11281/ADC/01/dkb.wps
16 June 2022

Application reference BR/124/22/HH
25 Pevensey Road, Bognor Regis, PO21 5NS

11281.31A

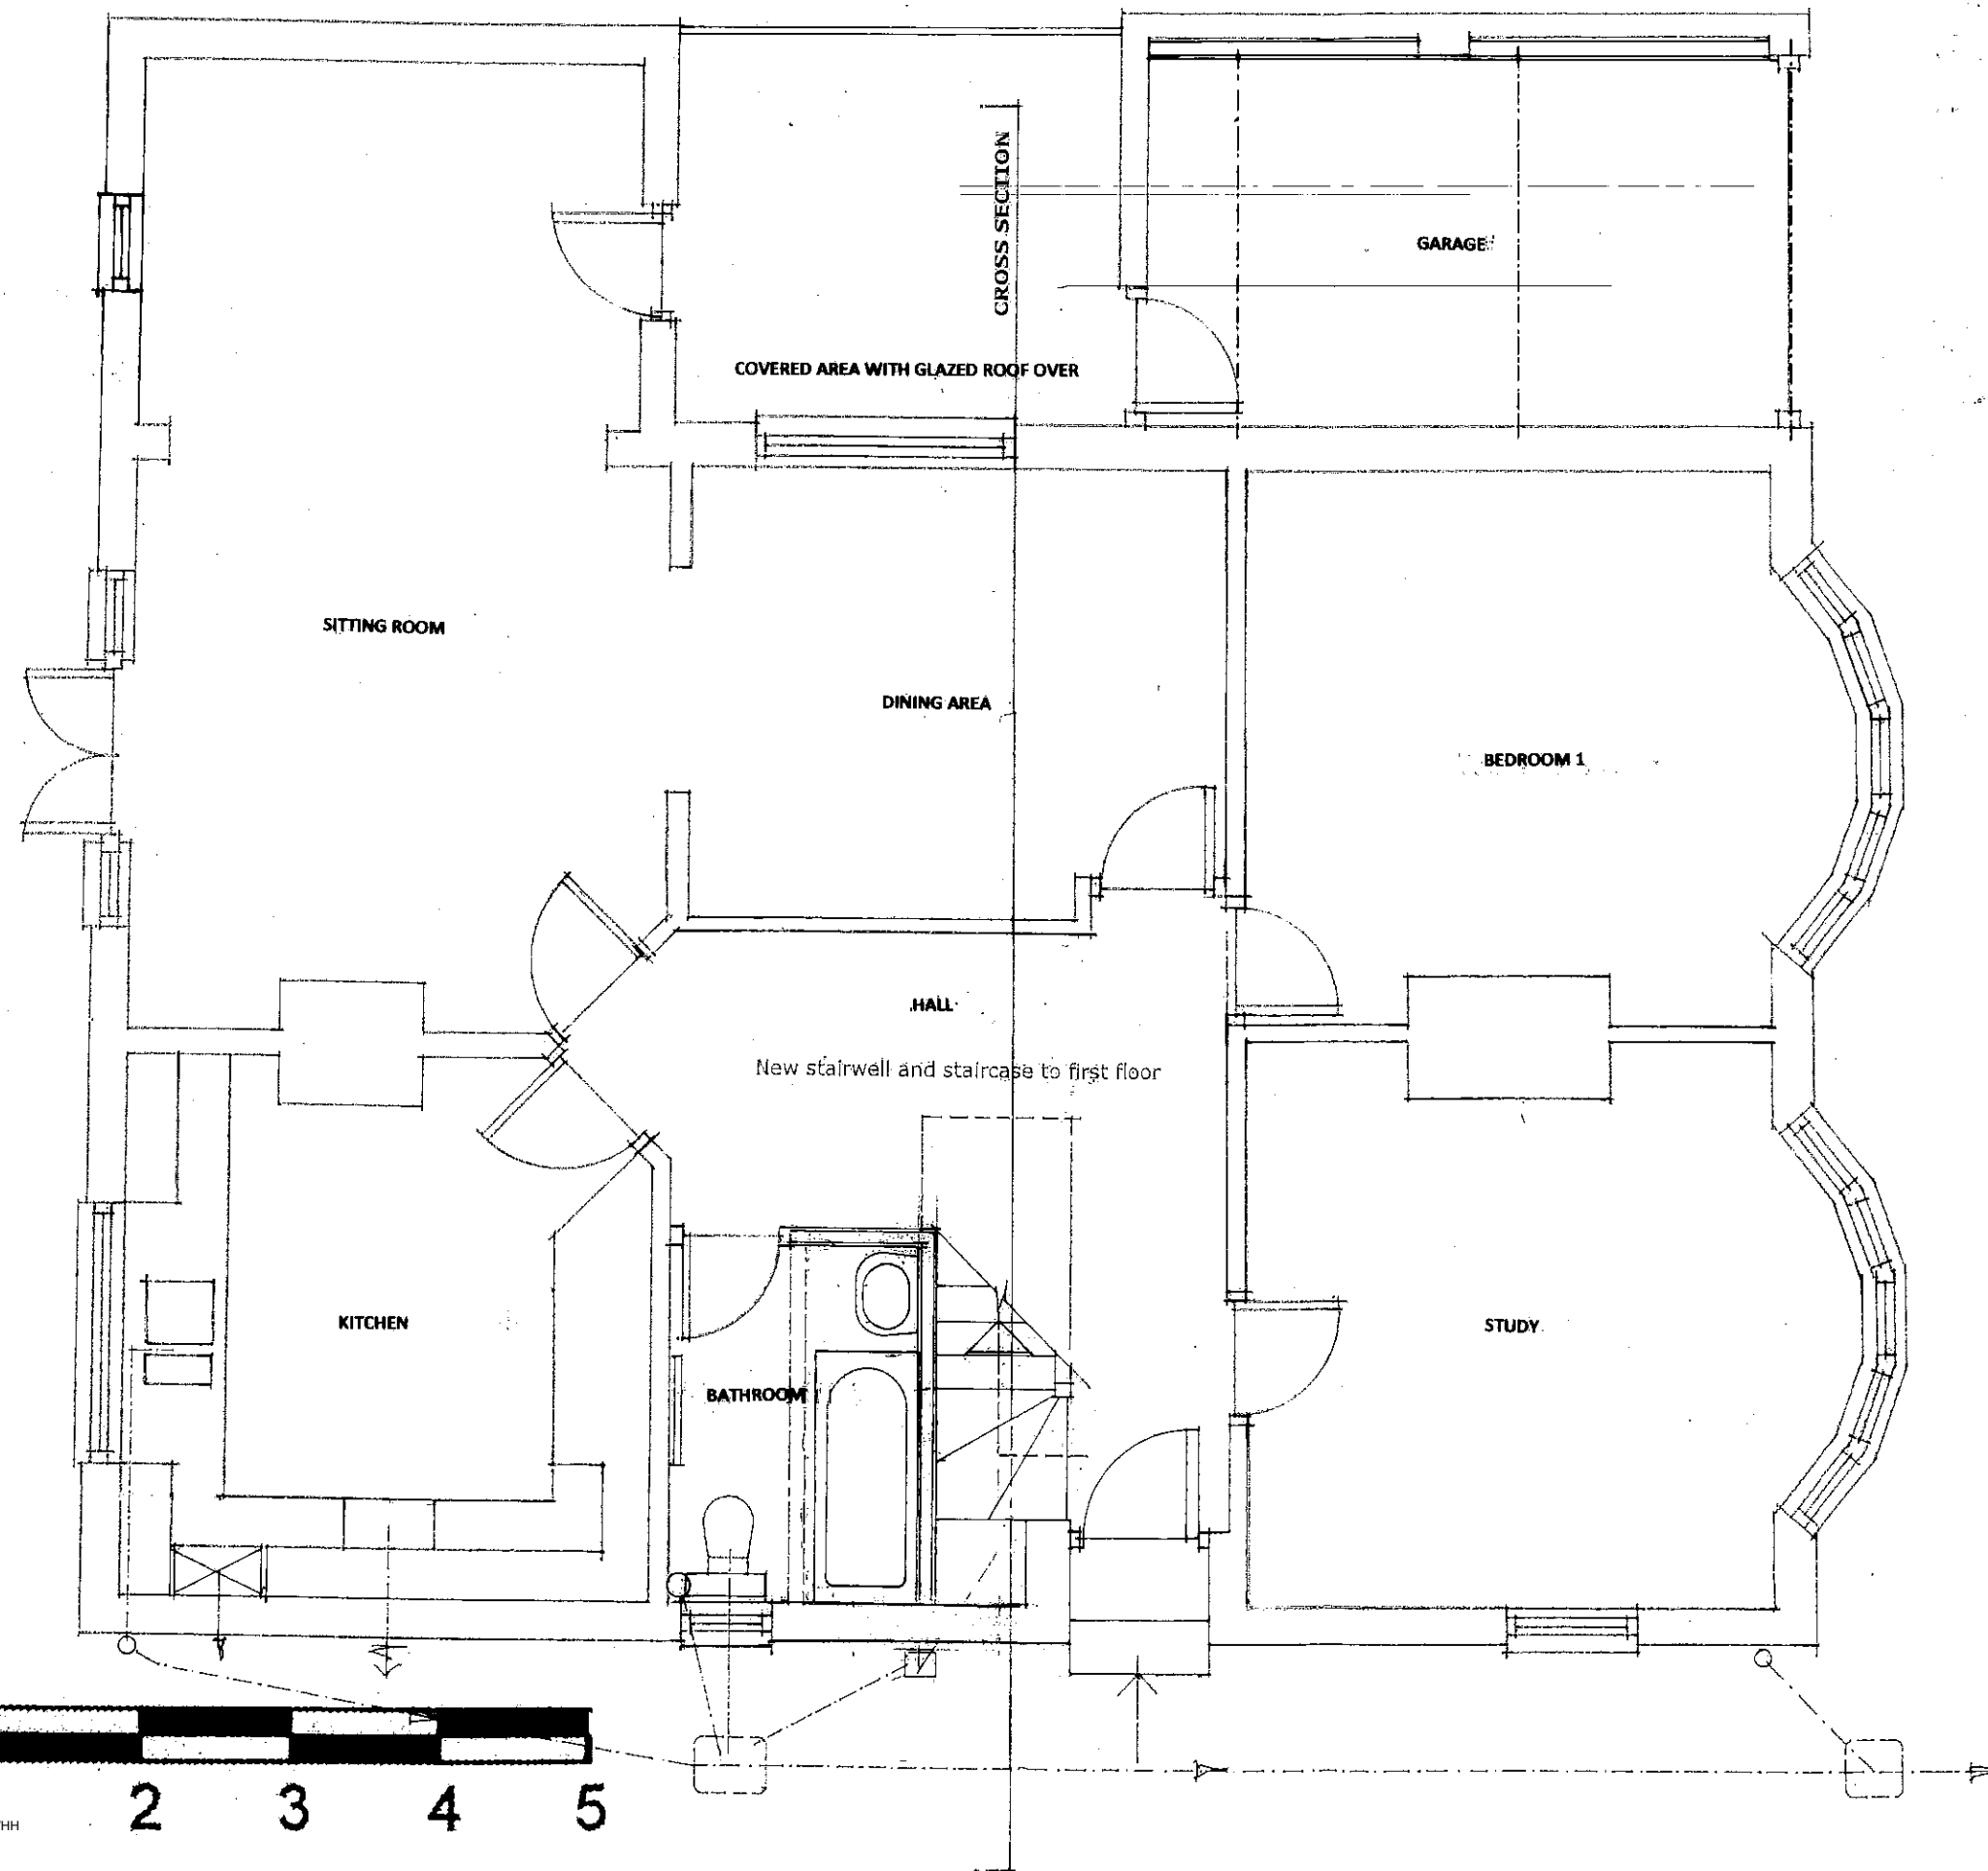
- 1 I confirm the applicants' acceptance of your amended description.
- 2 No work is required to the ground floor of this dwelling in order to carry out the proposed works. The existing floor plan is therefore sufficient.
- 3 Attached are drawings 11281.37A and 11281.38 illustrating the proposed forecourt parking area and crossover in more detail.
